Martin J. Chávez, Mayor

RE: GRADING PLAN FOR SEVEN BAR NORTH - UNIT B-5B (A-13/D7A)
RECEIVED APRIL 2, 1996 FOR R GRADING, FINAL PLAT & W.O.
ENGINEER'S STAMP DATED 4/1/96

DRAINAGE CERTIFICATION

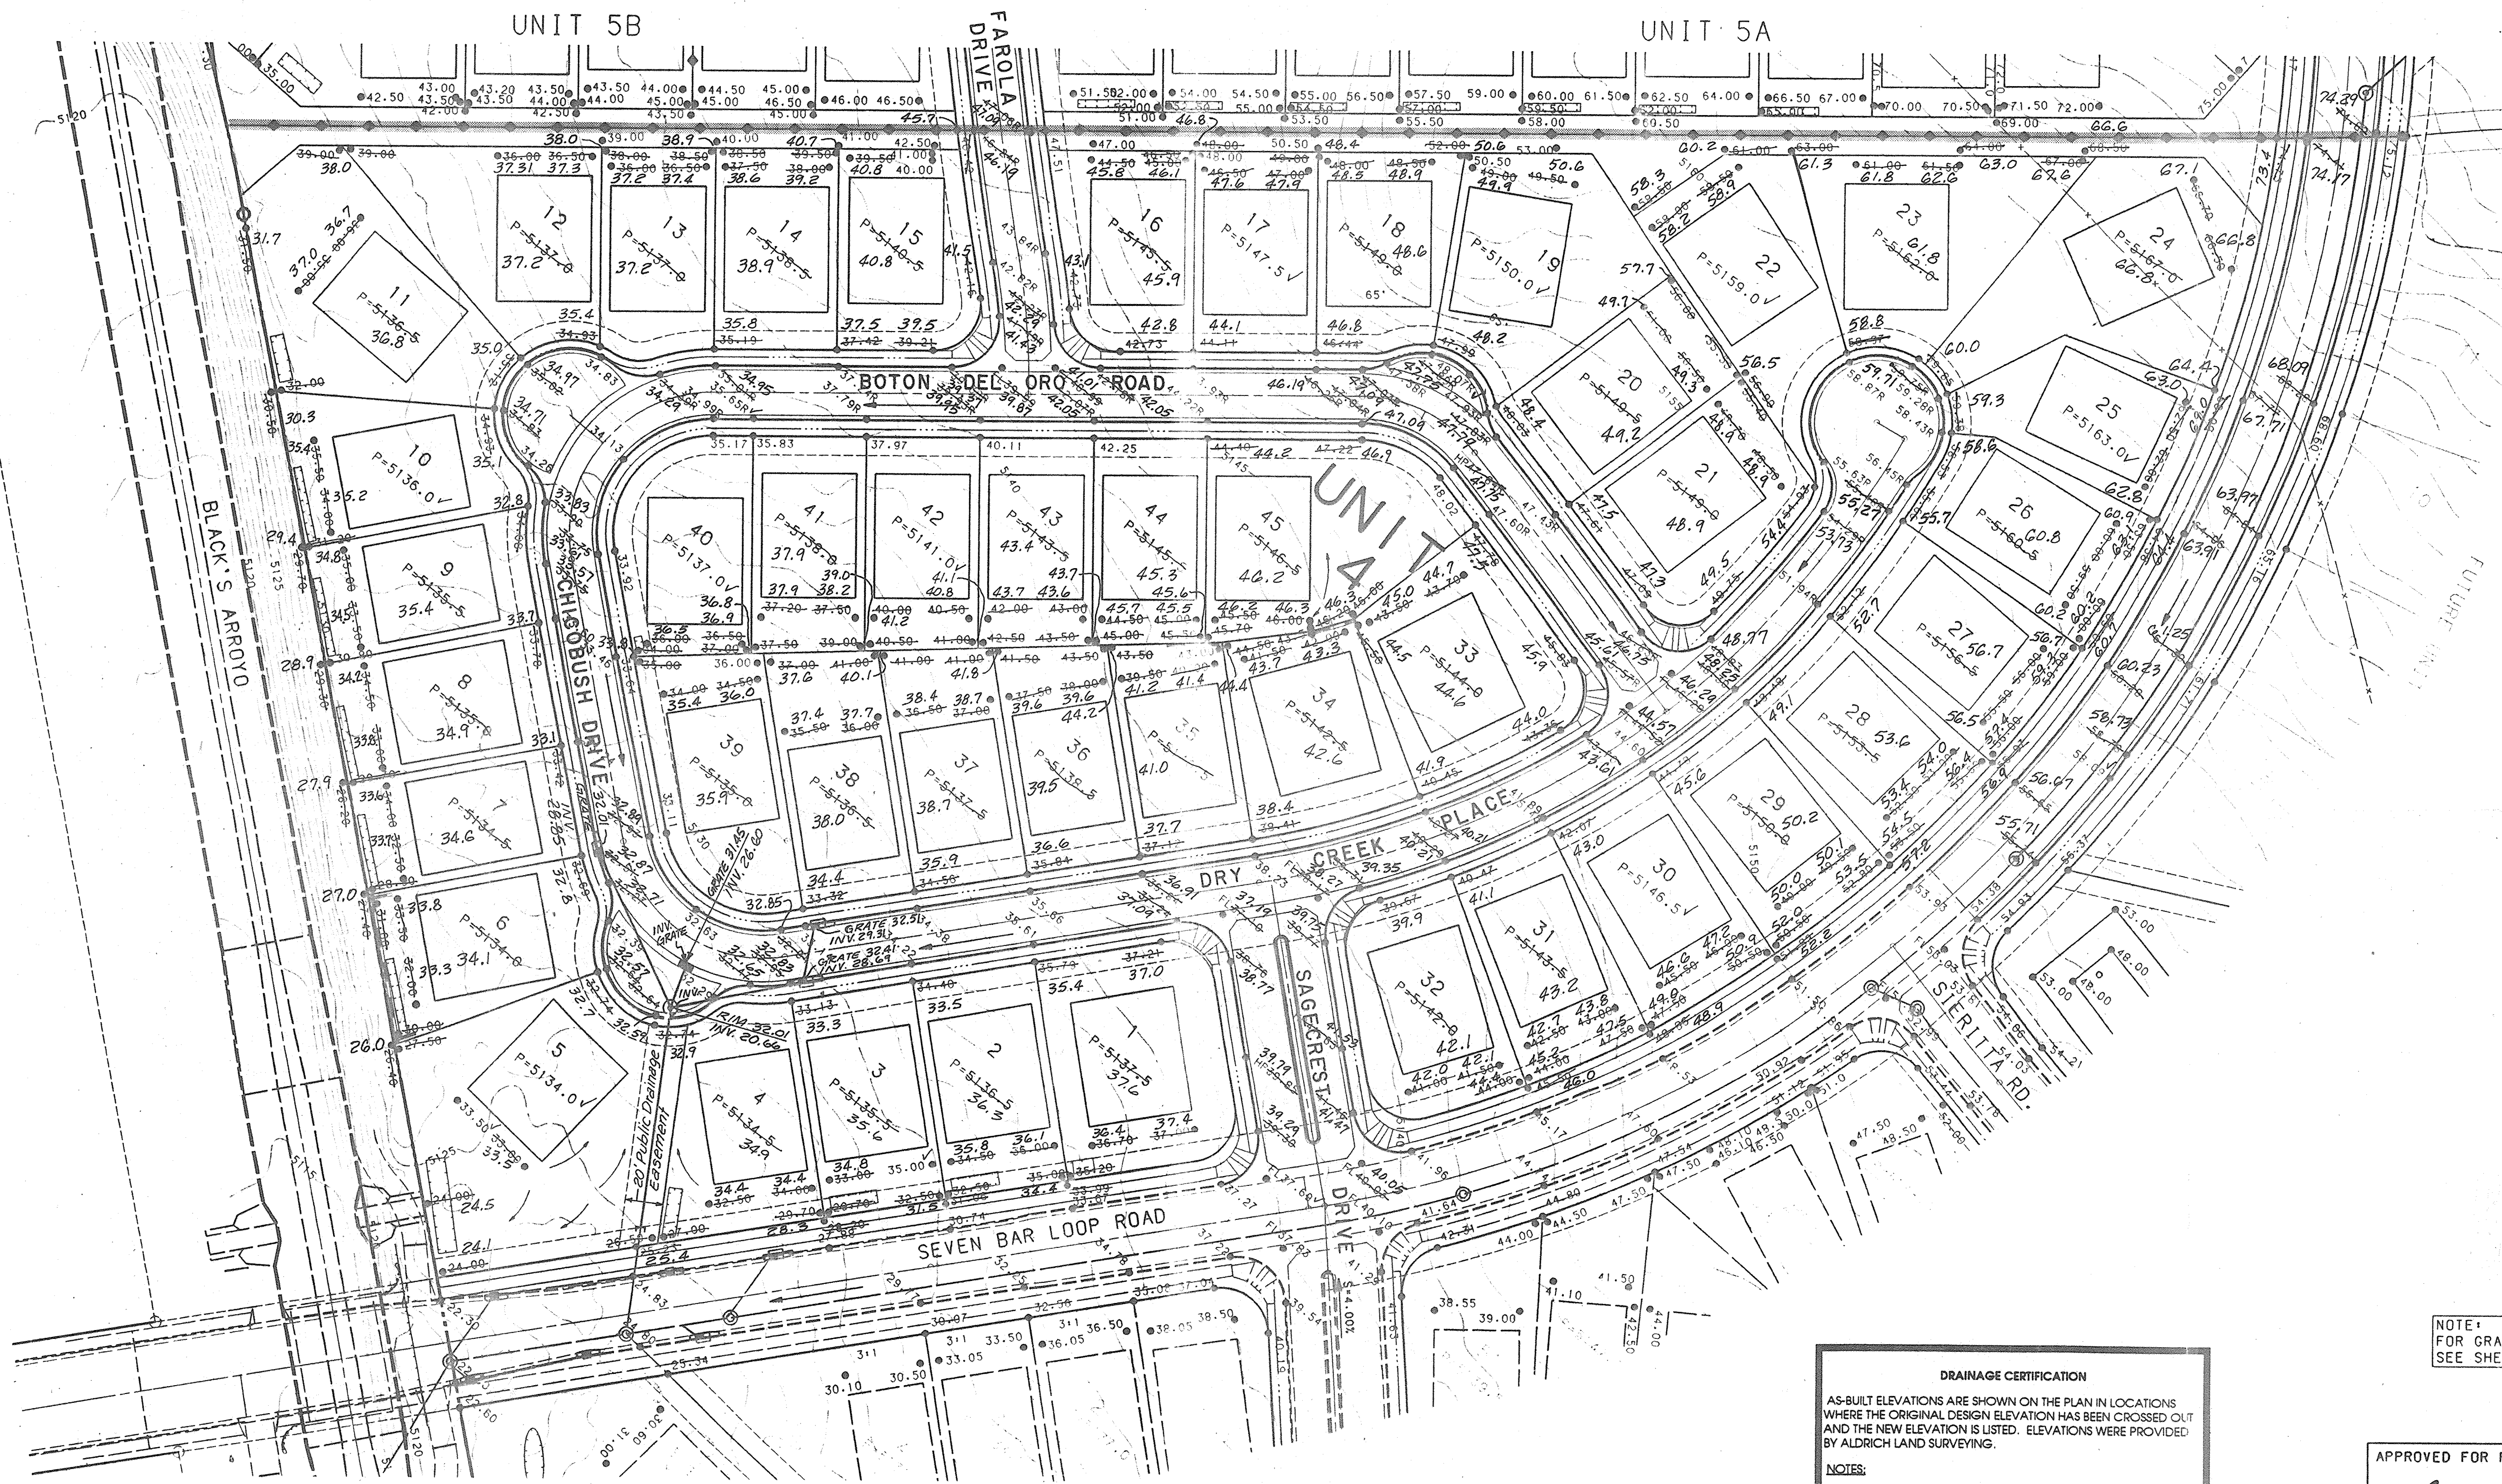
Indicate that mountable roll curb is proposed on Campo De Maiz Road. Provide a side lot grading detail which indicates the interim condition which will be certified before the garden wall is built.
